Michael Long
West Yorkshire Combined Authority
40-50 Wellington Street
Leeds
LS1 2DE

PLANNING APPLICATION REF: 2020/60/92331/E

PLANNING APPLICATION REF: 2020/60/92350/E

Thank you for consulting with the West Yorkshire Combined Authority on these applications. We apologise for the delay in sending these comments. Given the proximity of these site we have provide a single response for both sites.

Figure 4-2 Illustrative Masterplan

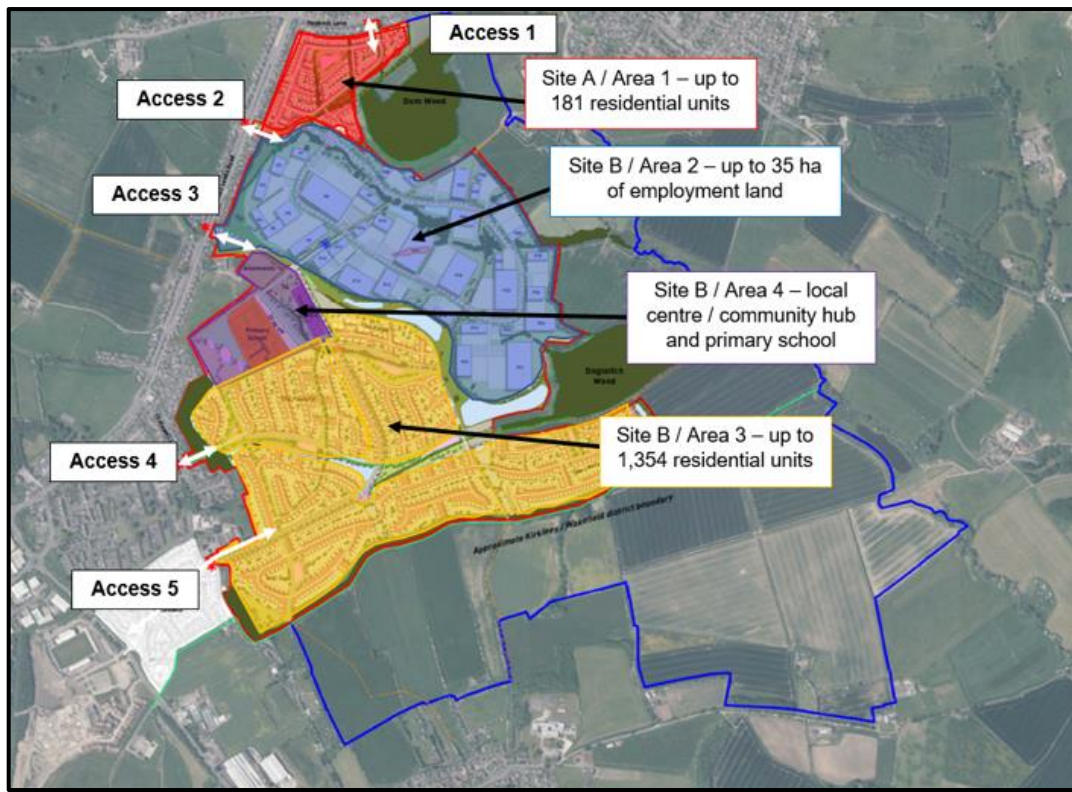
Given the size of the site, it is inevitable that parts of the site will not be within the 400m range of existing bus services. This is acknowledged by the applicant and we welcome the inclusion of the enabling infrastructure to allow buses to access the site. Regarding the access for buses to the site being from point 3 to 5 of the masterplan, has thought been given to buses serving the employment space too as this appears to have been overlooked. Allowing buses through the road marked

‘internal vehicular connection’ in the masterplan and through access point 2 would be an ideal opportunity to connect jobseekers with employment opportunities by bus.

The drawings are not particularly clear on what infrastructure there would be for buses within the site. The applicant needs to identify where the bus stops planned on the through route will be located and consider bus laybys (particularly relevant near the local centre).
